Subject: RE: Planning Consultation on EP/48/20/DOC

[REDACTED]
Engineers Comments Regarding Surface Water Drainage

APPLICATION NO: EP/48/20/DOC

Site Address: 16 Worthing Road East Preston BN16 1AZ

Trial Pit Number: **TP01**

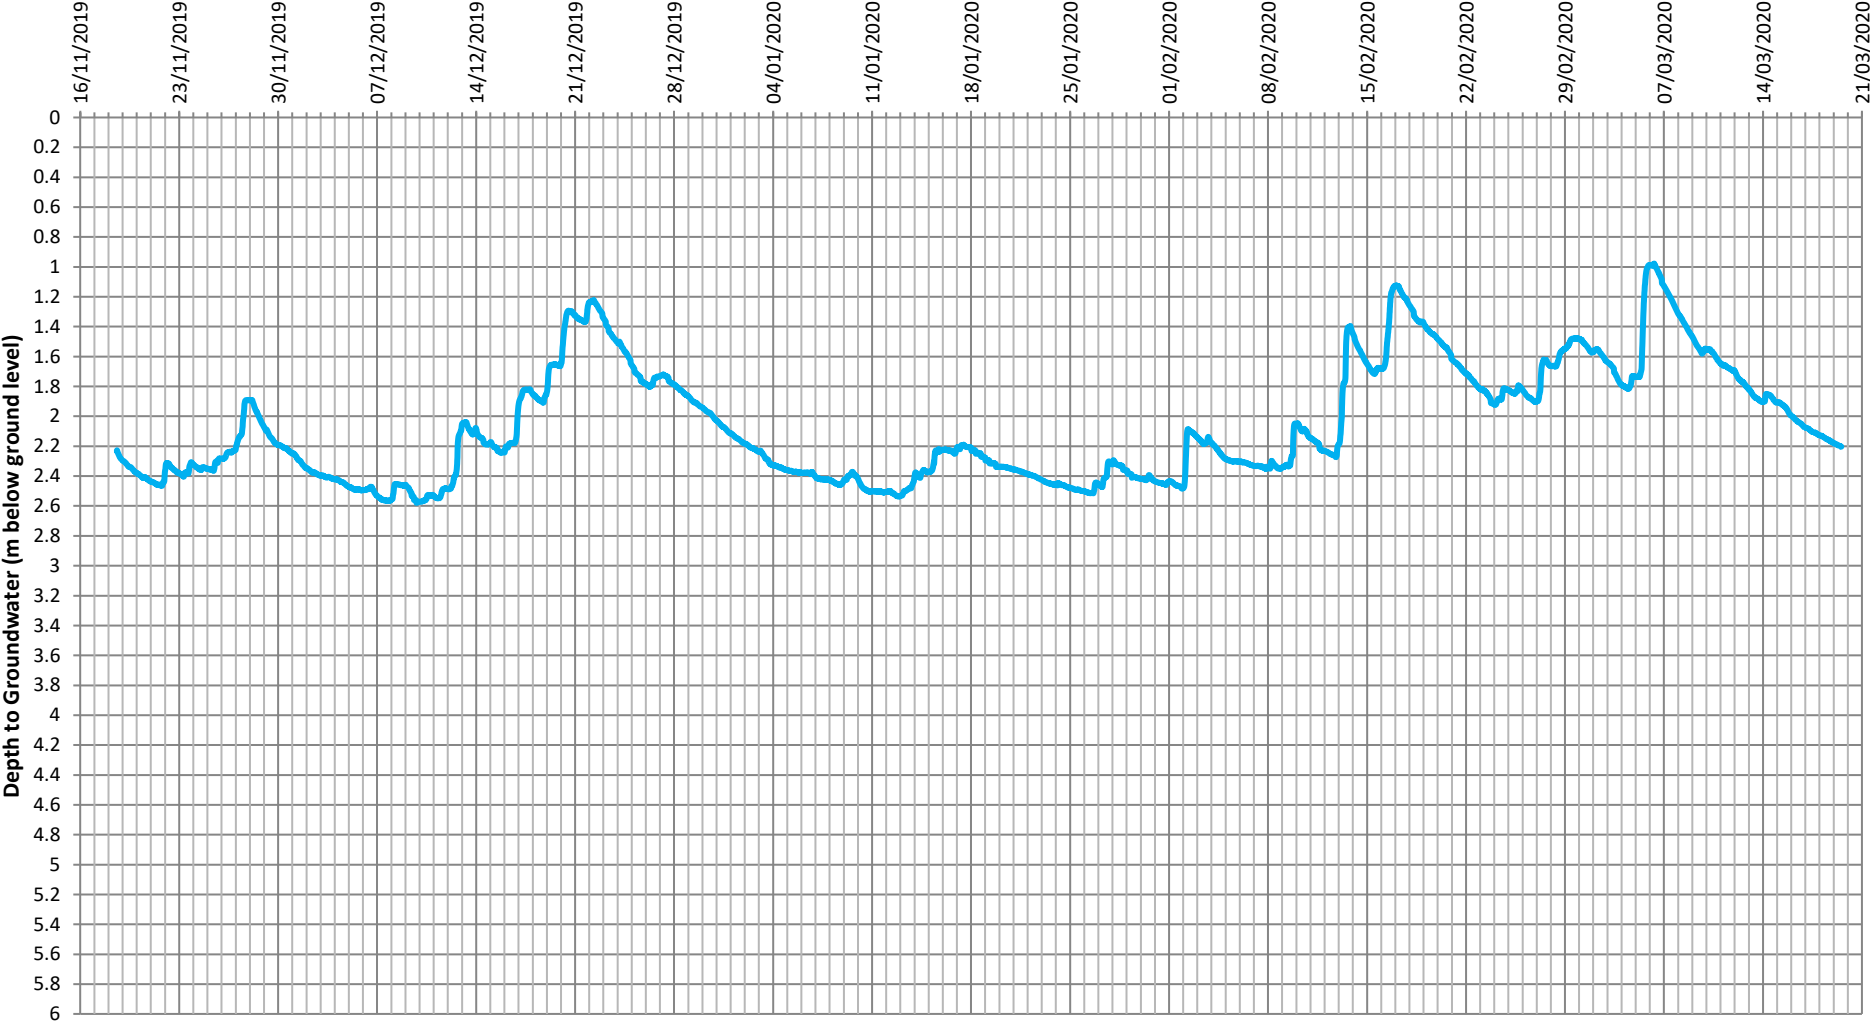
1. The trial pit TP01 is undersized (0.3m x 0.3m rather than 0.3m x 1m specified by BRE365). Please apply a safety factor of 3 to the calculations. Three tests were completed, the date of testing is assumed to be 24/01/2018 (from the test pit stratum record) however this is not clear. Please clarify.
2. Construction detail drawings need to be included for:
 - a. Inspection chambers
 - b. Channel drains
 - c. Pipe bed and surround

As discussed in Section 4.1 of our report, the fieldwork (which included the soakage testing) was undertaken on 24th January 2018.

APPENDIX F – SITE DRAINAGE PLAN AND DETAILS

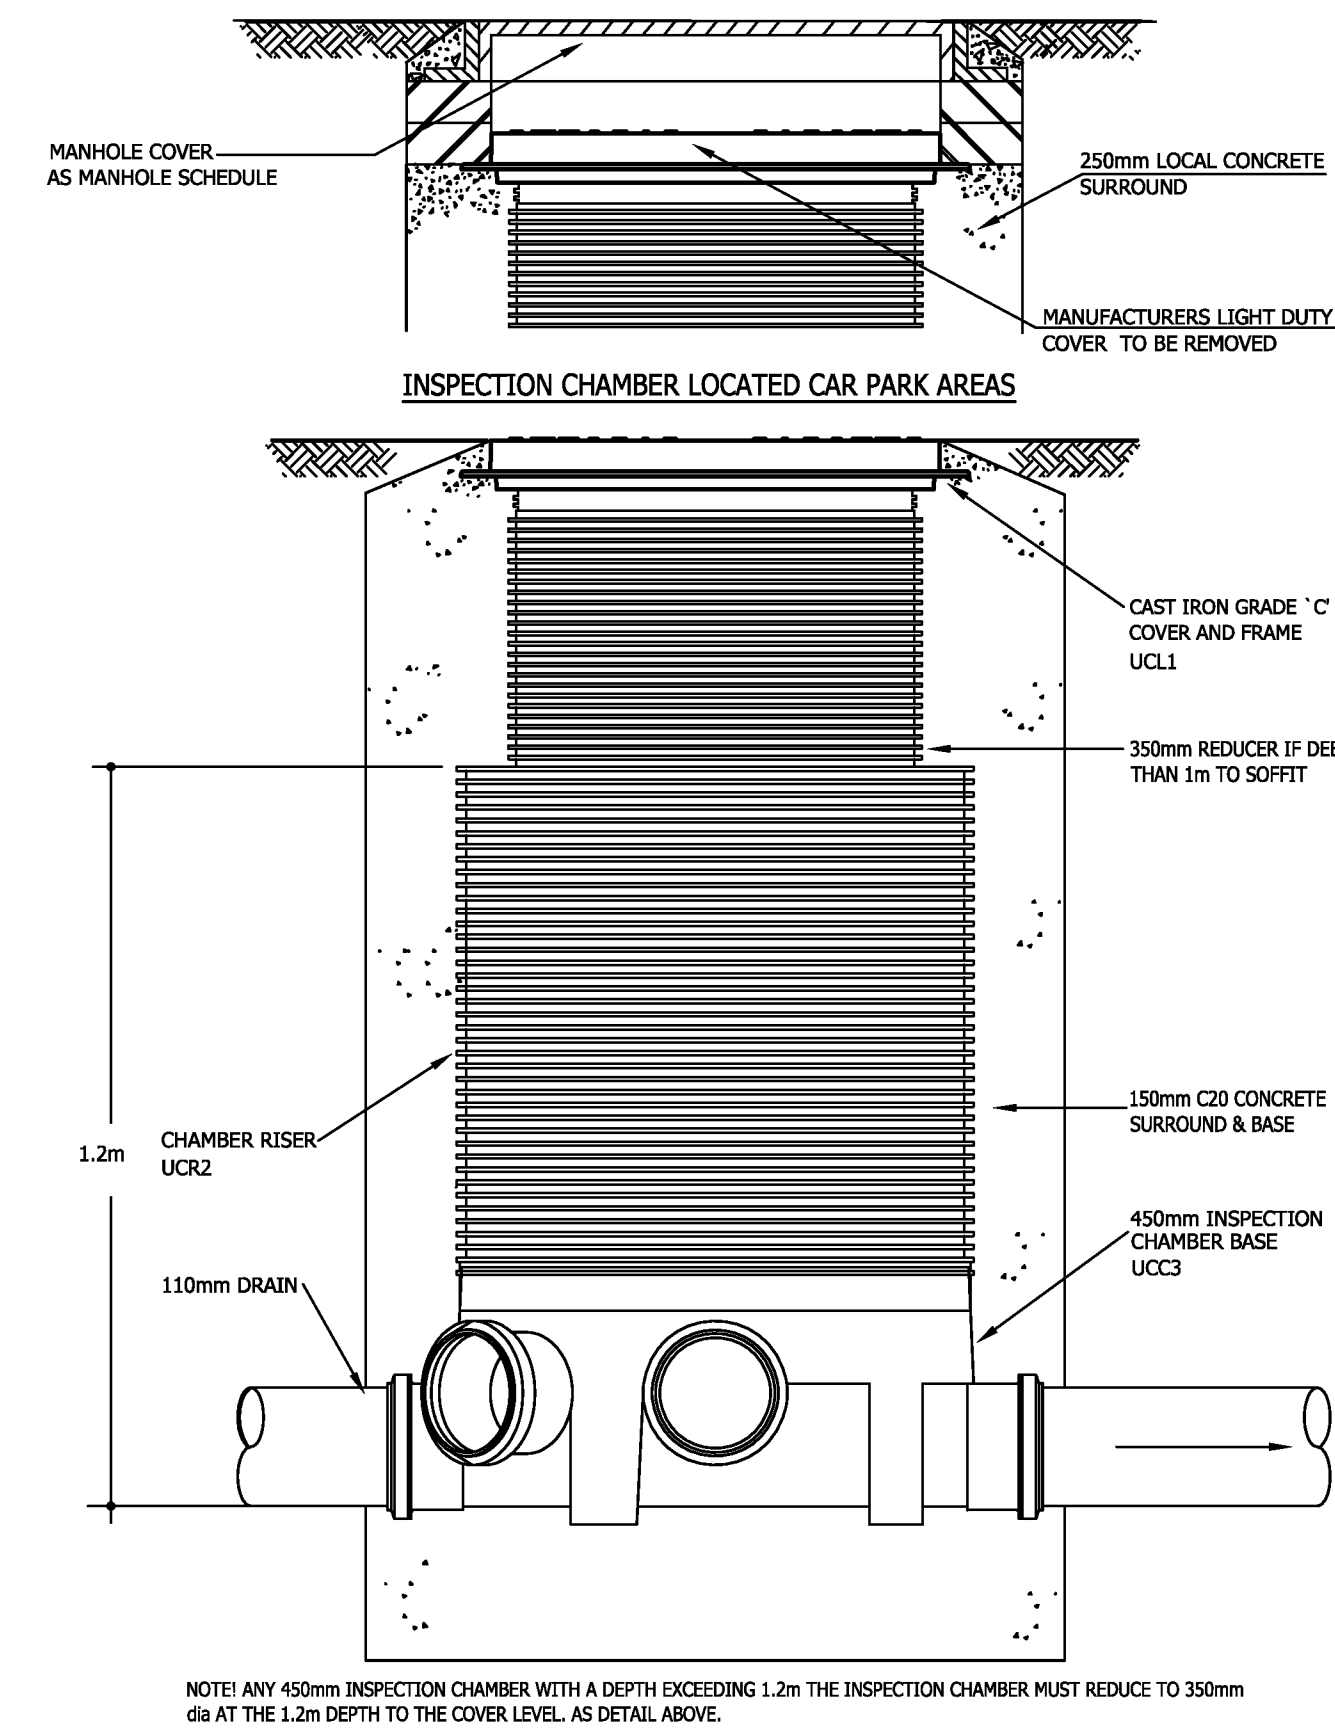
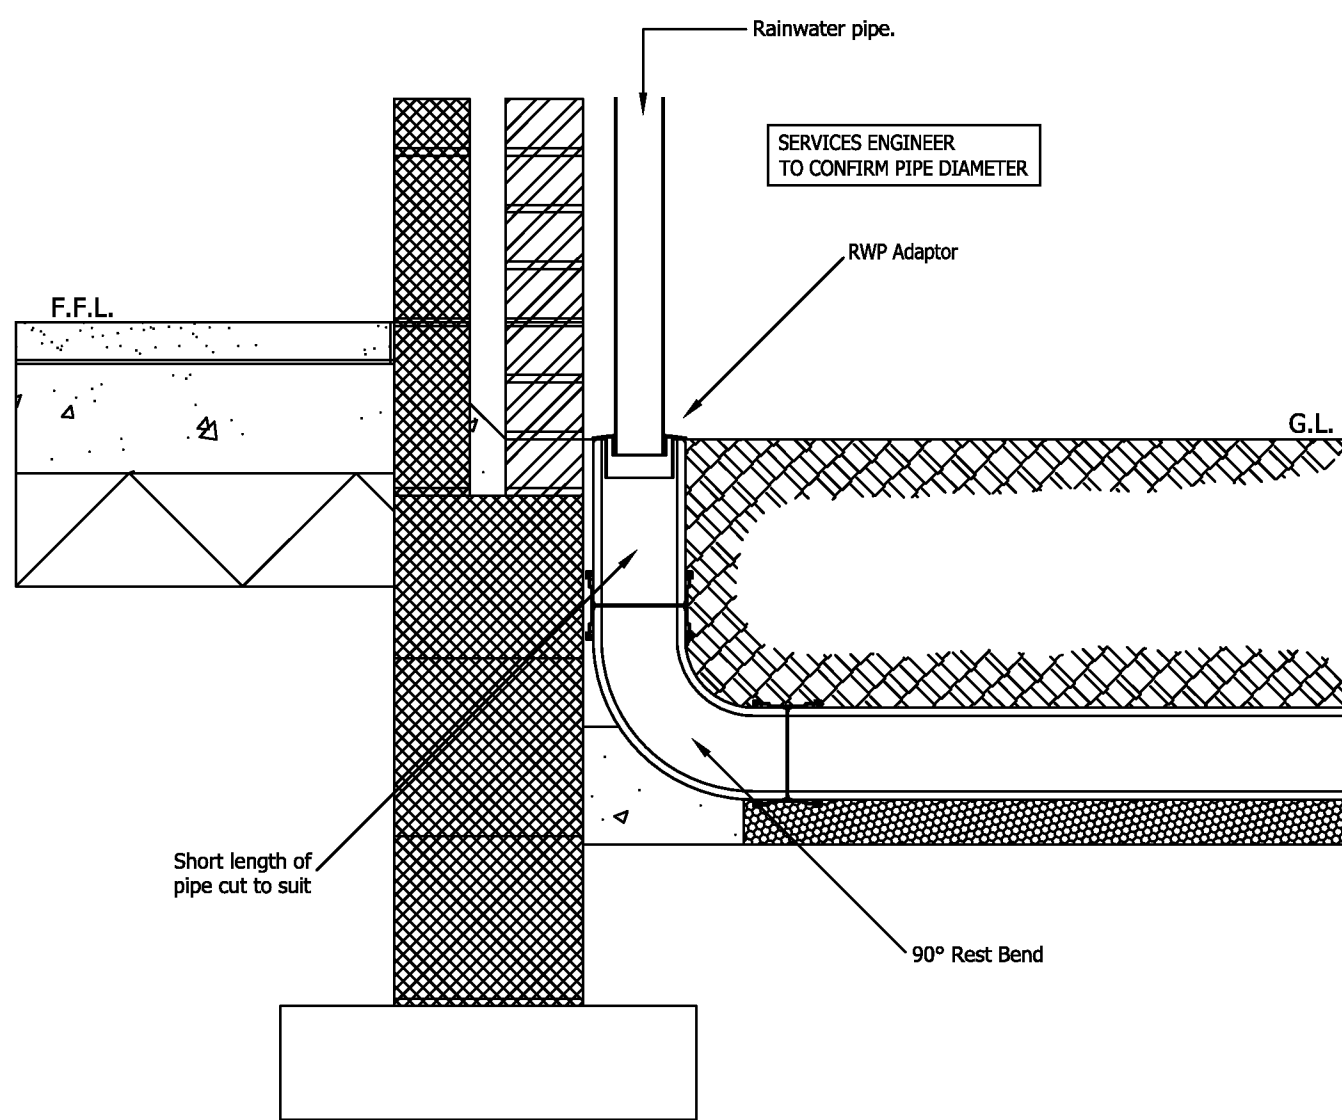
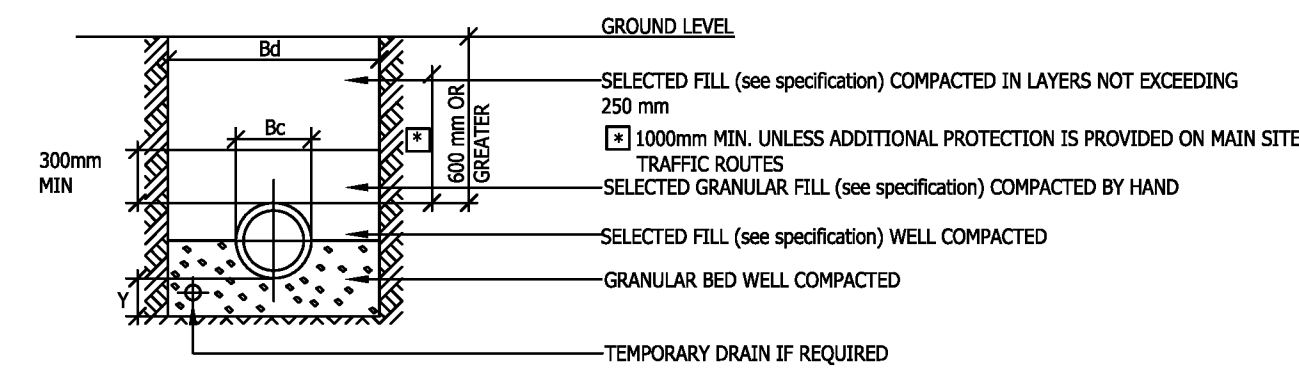
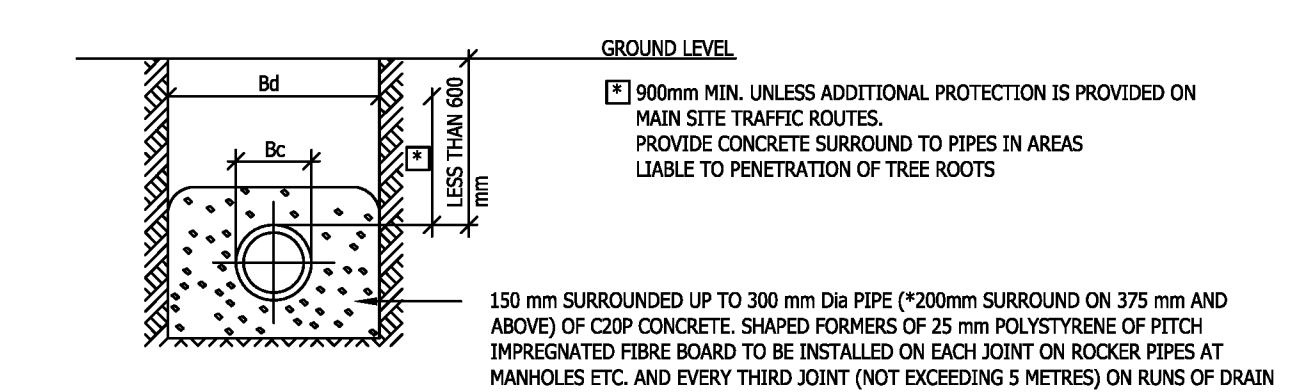
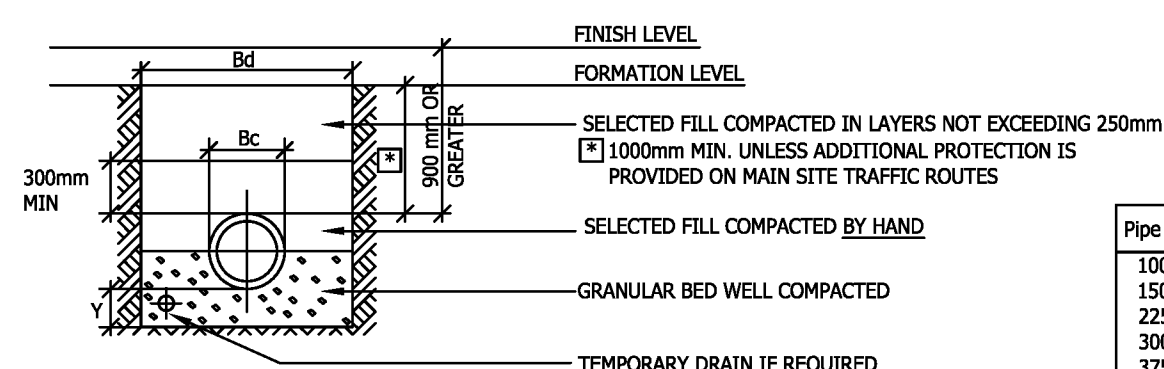
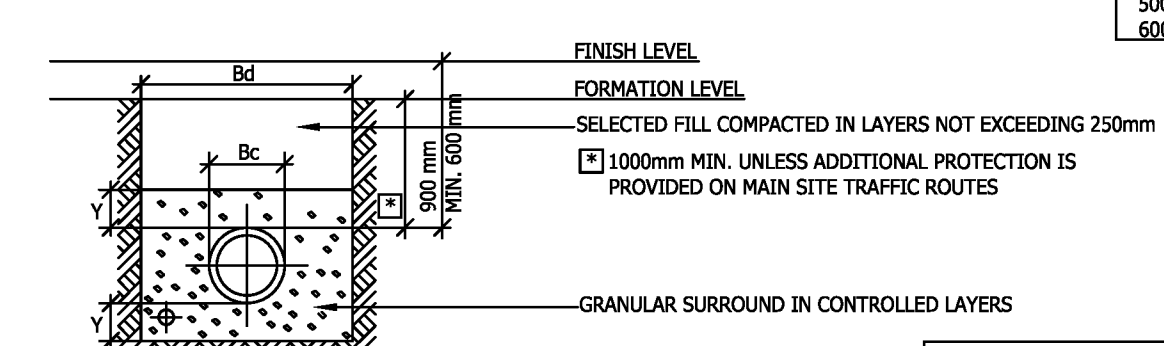
Updated plans/construction details (to discharge condition 10) will need to be included.
